Our Case Number: ABP-317742-23

Re: BusConnects Bray to City Centre Core Bus Corridor Scheme
Bray to Dublin City Centre.

Bray to City Centre Core Bus Corridor (Bus Connects) Scheme

9th October 2023

Image 3.13: Section 3 Route Options Remaining After Stage 1 Sifting (Bray to UCD CBC Feasibility and Options Report (NTA 2017))

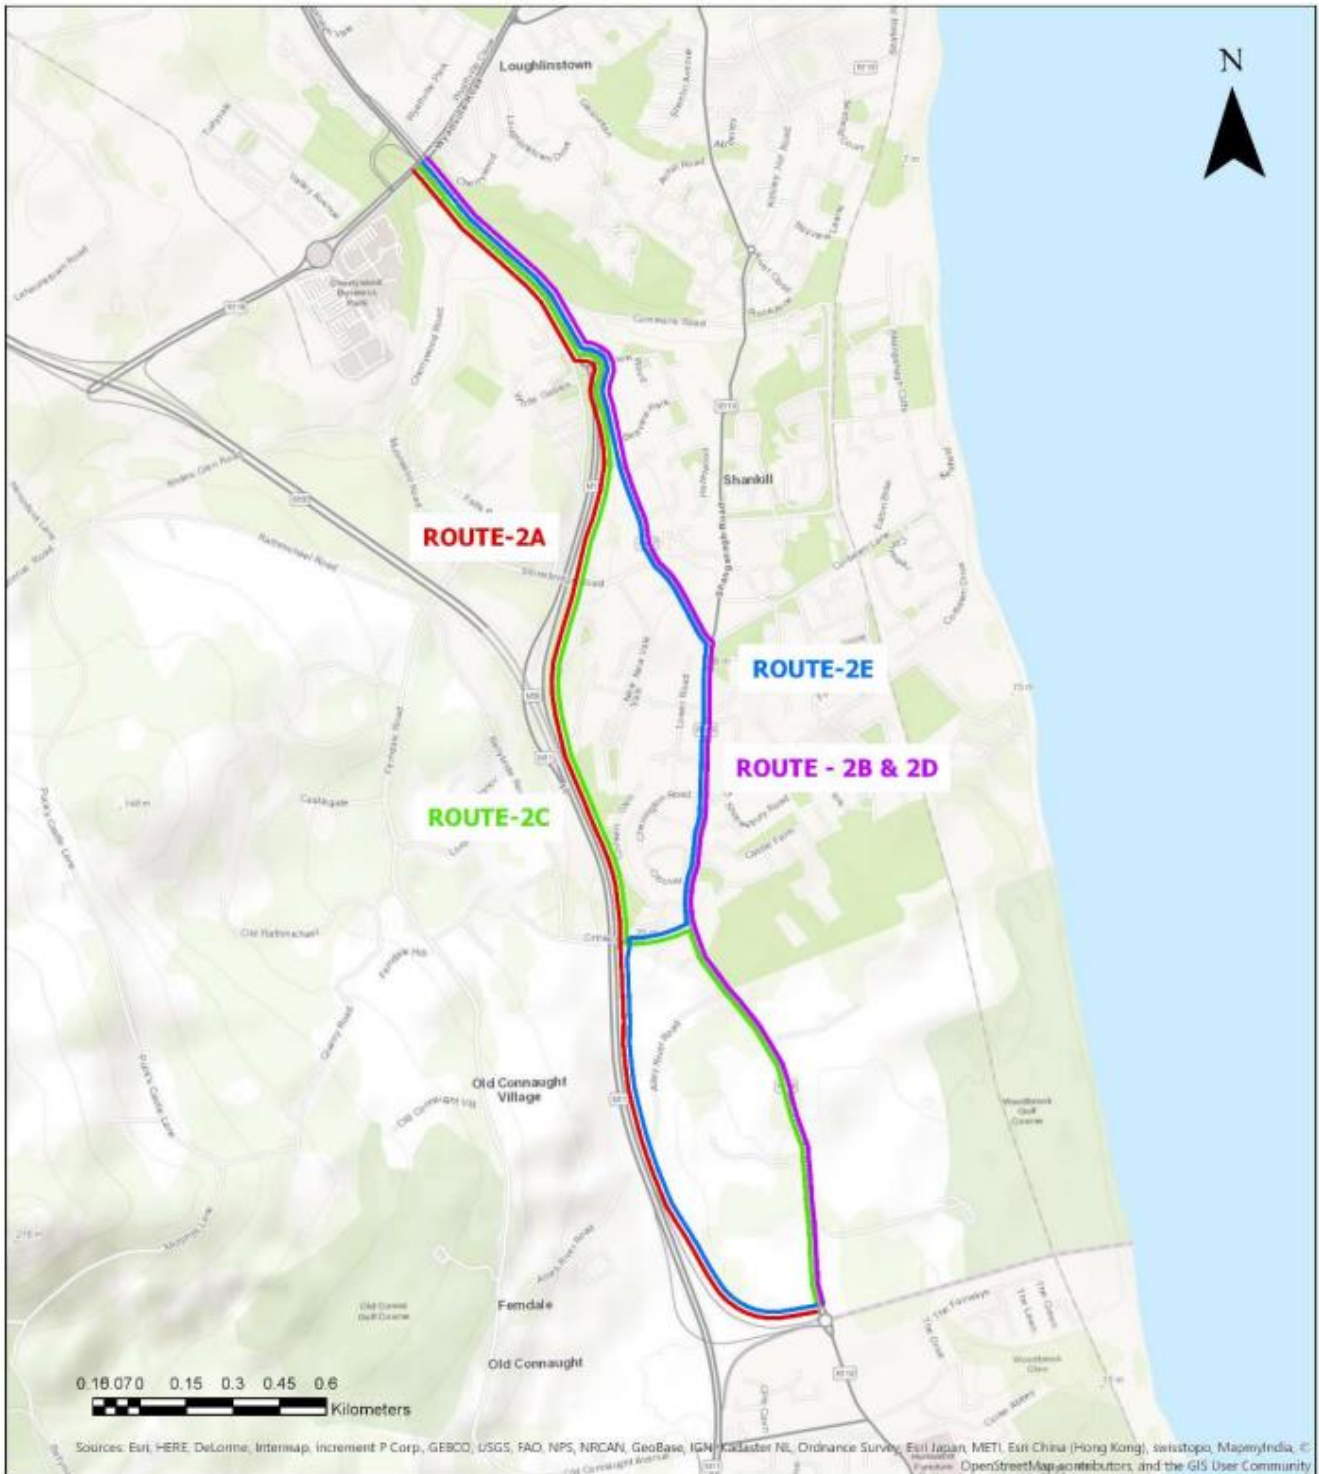
The process to select the preferred route through Shankill has not taken adequate consideration of the subsequent significant design changes to the preferred route and the resultant significant reduction in level of service provided for both bus and cycle infrastructure since the route was first chosen. This is particularly relevant given the relative “closeness” of the preferred route to that of the alternative (route 2A) which runs alongside the M11 (which was in fact much more favourable in terms of environmental impacts).

The Route Options Assessment (Feasibility Report 2017) noted that whilst Route 2B was considered preferable due to the lower capital cost when compared to Route 2A, it provided significantly less journey time reliability. It can therefore be concluded if:

- Route 2B was only slightly more favourable than 2A (and indeed 2A was significantly more favourable from an environmental impact perspective) and that;

- The journey time reliability of 2B is now further diminished due to the subsequent reduction in dedicated bus infrastructure (and its replacement with the less reliable bus priority measures), along with significant reductions to dedicated cycle infrastructure, and also that;
- The capital cost of 2A has been overstated, i.e. a significant portion of the costs will be incurred irrespectively with the provision of the N11/M11 Interim Bus Priority scheme, the longer term J4 to J14 Improvement Scheme and the future provision of the LUAS;

Therefore the assessment and conclusion that route 2B remains preferential and somehow performs better (economically and environmentally) than the alternative route 2A is fundamentally flawed and factually incorrect.

Image 3.15: Alternative Cycle Route Options Through Shankill (Bray to UCD CBC Feasibility and Options Report (NTA 2017))

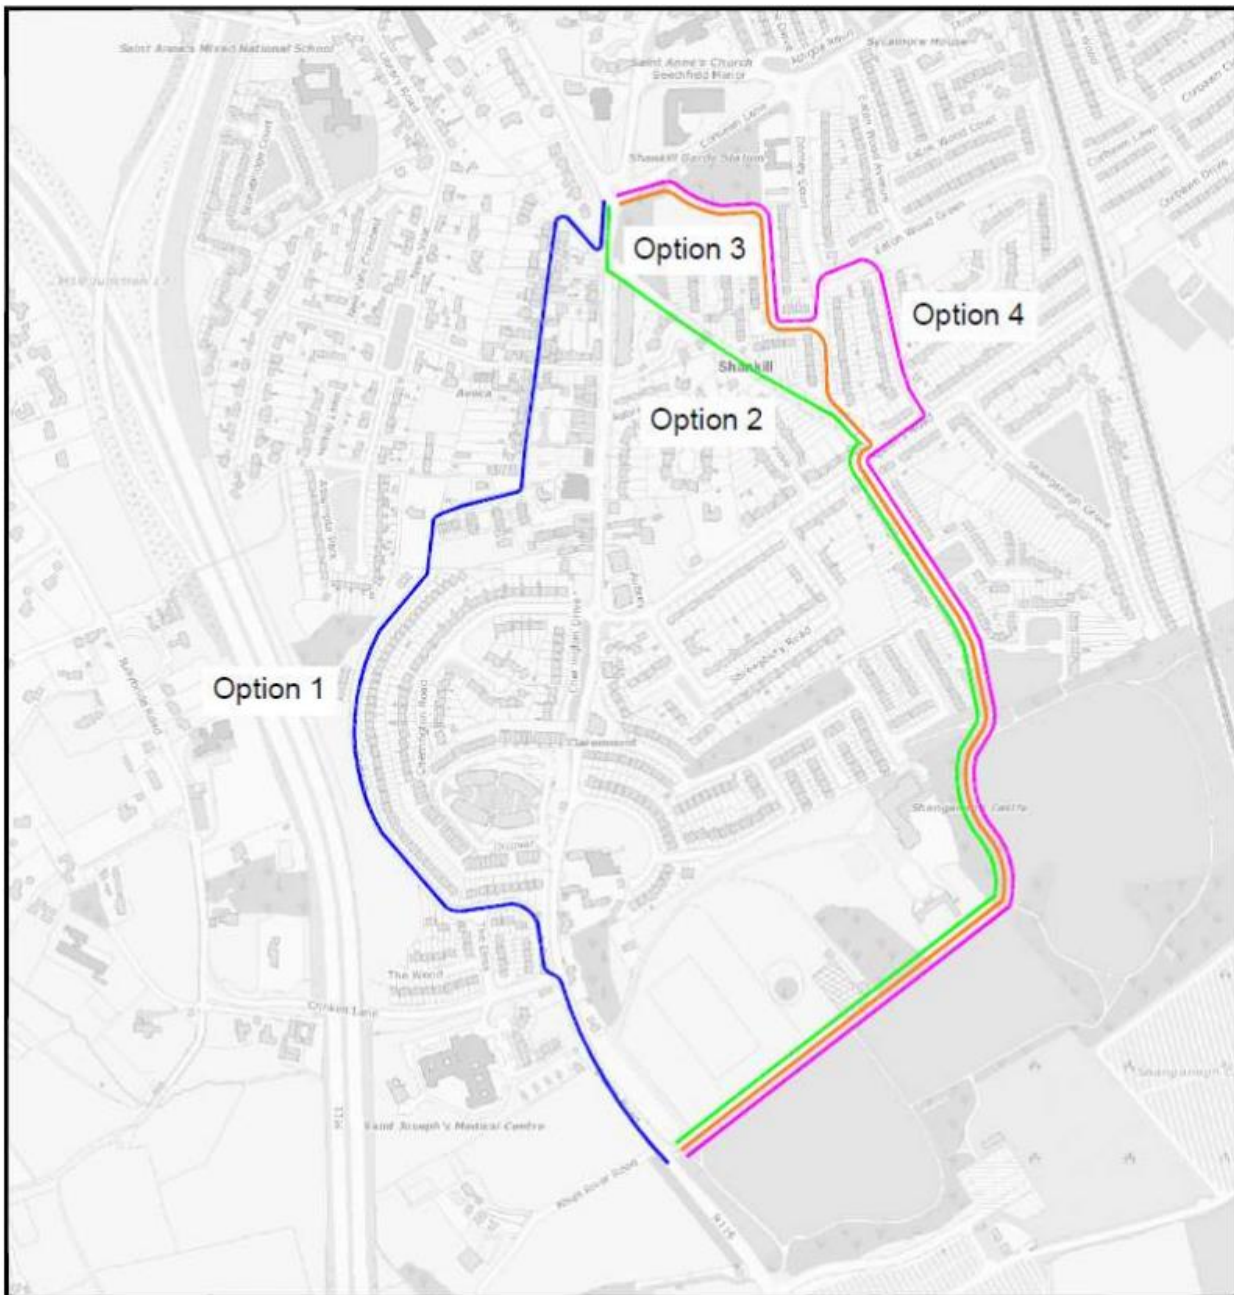
The proposed route serves a number of schools (primary and post primary), however only a short section of two-way cycle track has been provided, whereas the remainder of the route from Loughlinstown Roundabout to south of Shankill village has made no provision for cyclists. Noting the NTA’s own cycle standards, it is not safe for children of that age to share bus lanes with buses and taxis as proposed. Indeed, recent reports (Journal.ie, September 2023) highlights “*new research that has found that close to 70% of children killed or seriously injured on Irish roads were either walking or cycling at the time*”, thereby reinforcing the principle of considering Vulnerable Road Users first when designing schemes, which the proposed scheme has not done.

The Road Safety Audit (Stage 1) highlights the concerns of the auditors with the lack of provision for cyclists through Shankill and the increased potential for conflicts with vehicles. The subsequent
